REQUEST

Current Zoning: N1-D (Neighborhood 1-D)
Proposed Zoning: MUDD-O (HDO) (Mixed-Use Development District, Historic District Overlay)

Approximately 3.23 acres located on the northeastern corner of the intersection of West Boulevard and Mint Street.

STAFF RECOMMENDATION

RZ - 200

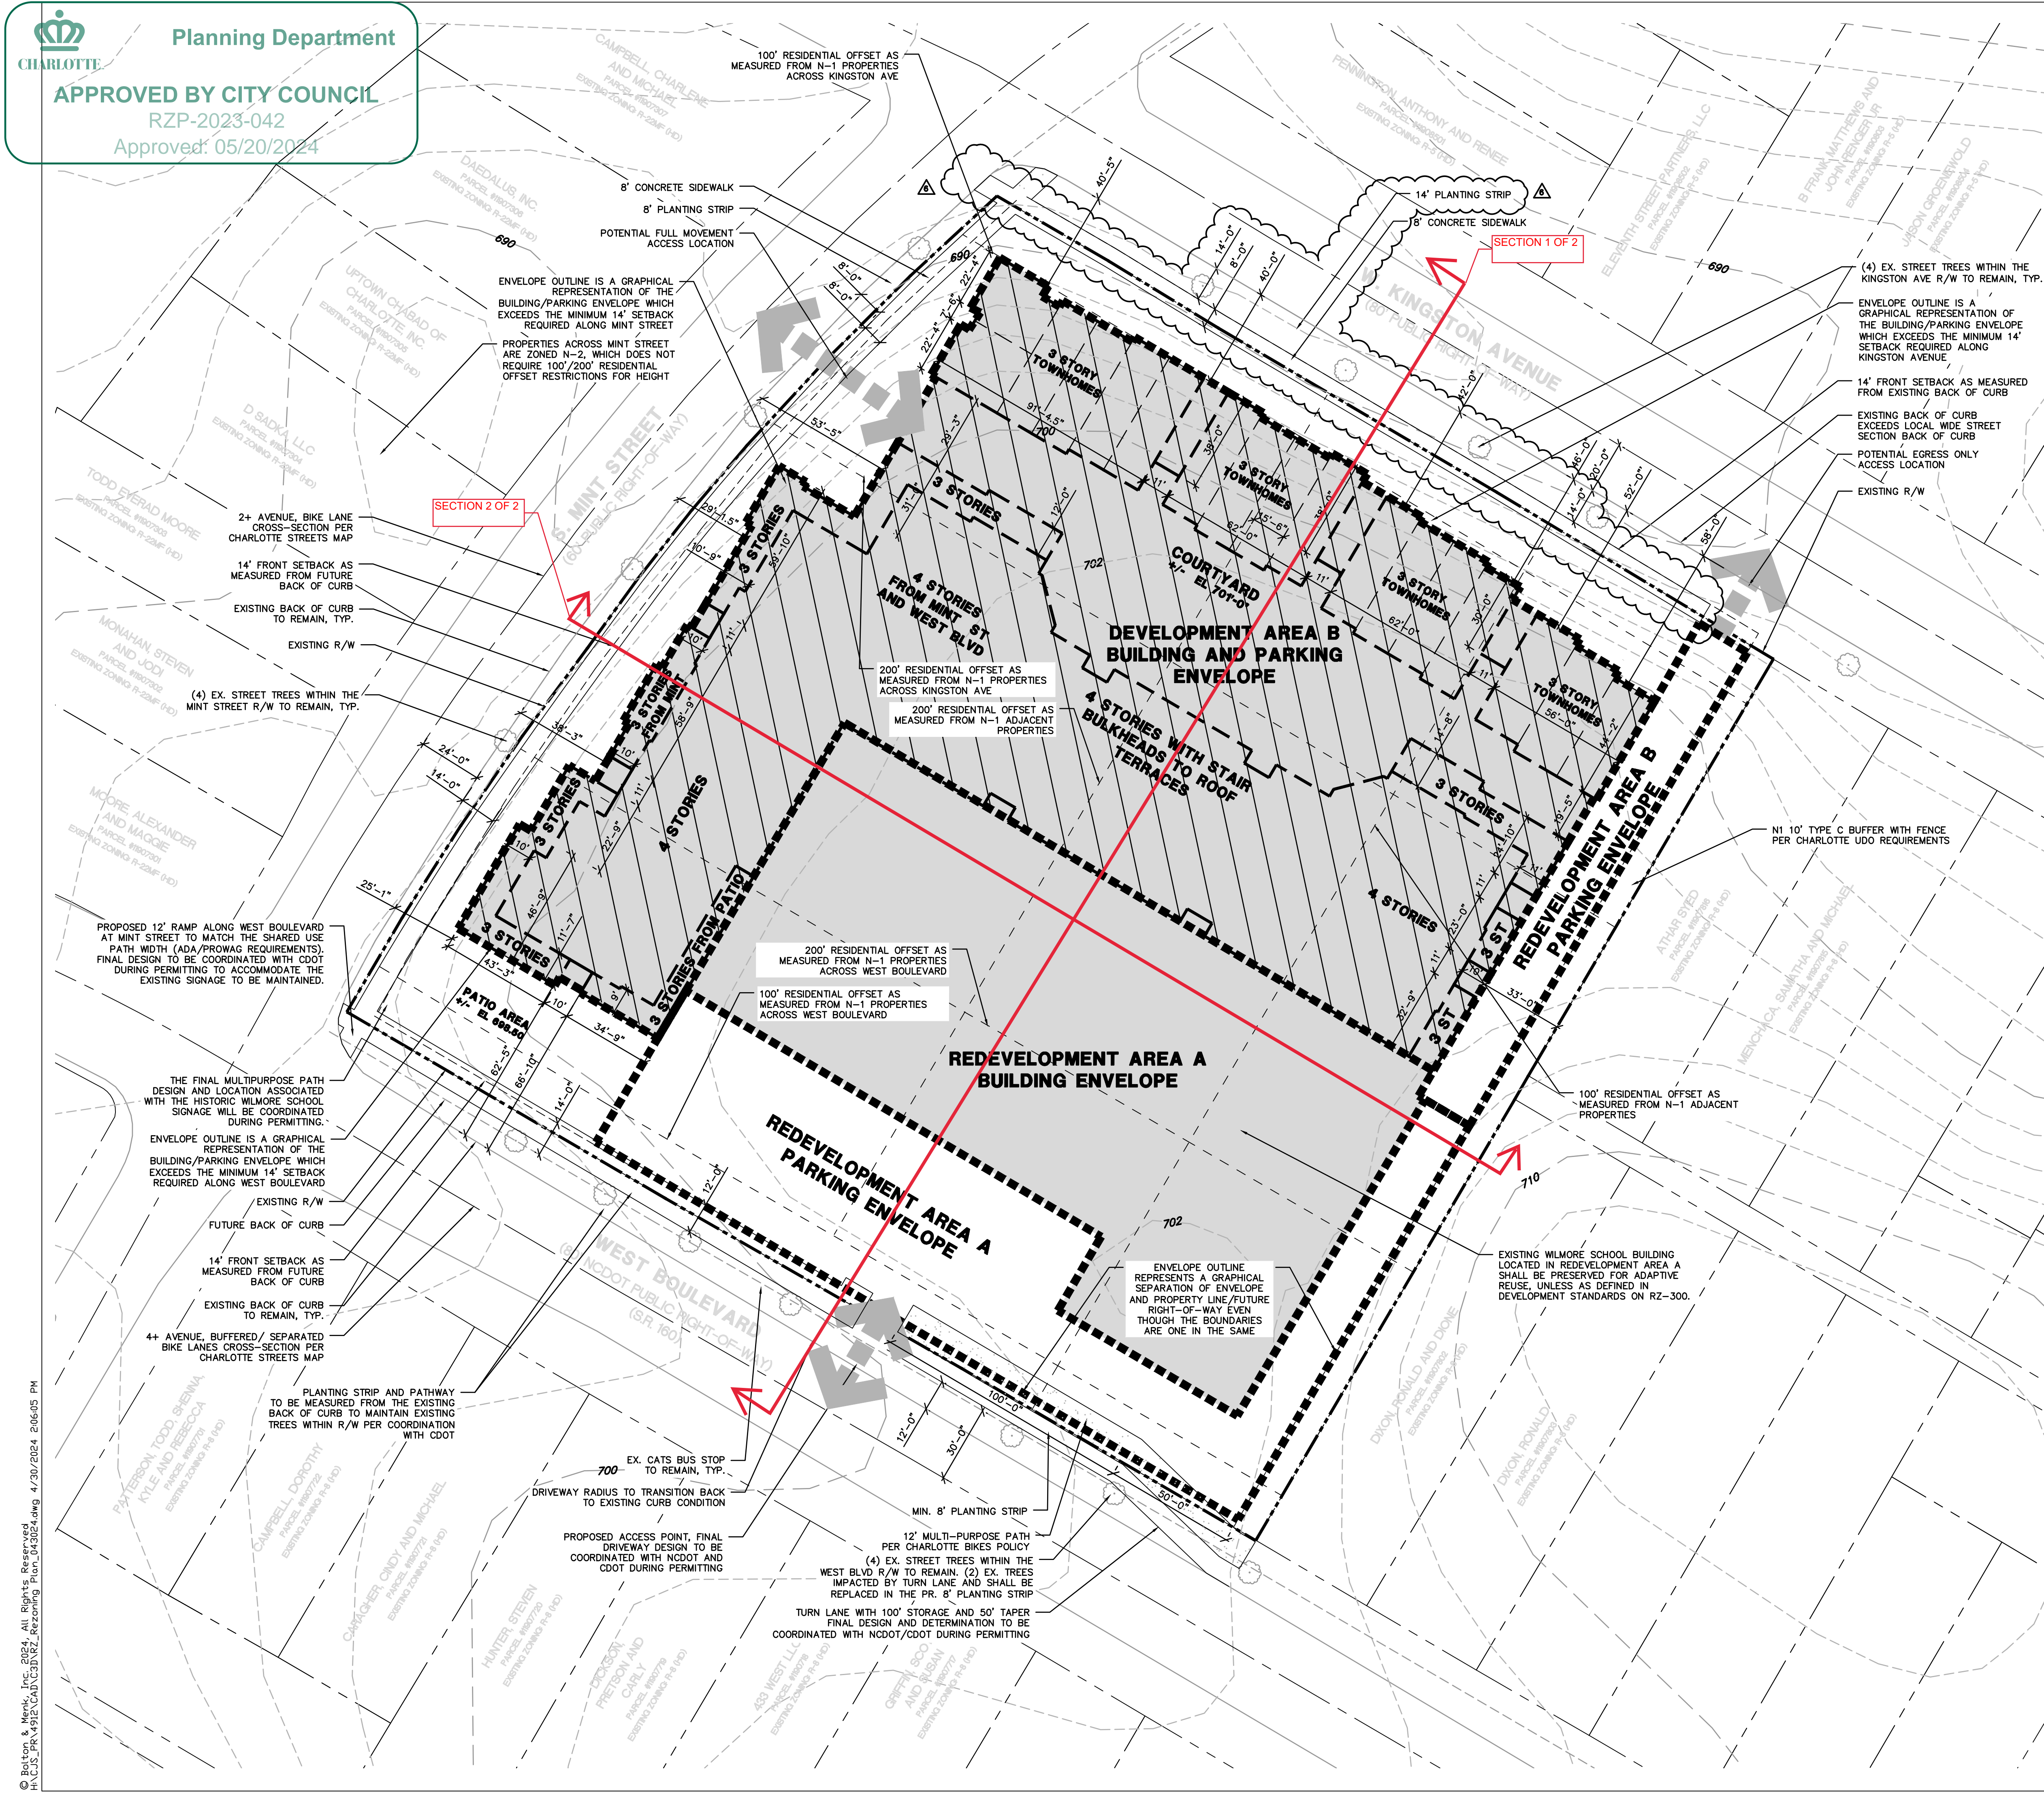
1. Illustrate a proposed 12' ramp along West Boulevard at Mint Street to match the shared use path width (ADA/PROWAG requirement).

2. Revise the conditional rezoning plan to match the approved HDC site plan. Correct small measurement discrepancies between the rezoning site plan and approved HDC site plan. Use feet and inches in rezoning site plan measurements. Measure from the same points used on the HDC approved plans.
 3. Add the following conditional note: "In the case of any discrepancies between the conditional rezoning plan and HDC approved plan, the HDC approved plan shall supersede."
 4. Add the following conditional note: "In the event that the historic school building is demolished, the entirety of the new structure(s) and site must meet MUDD standards and will be subject to HDC review."
-
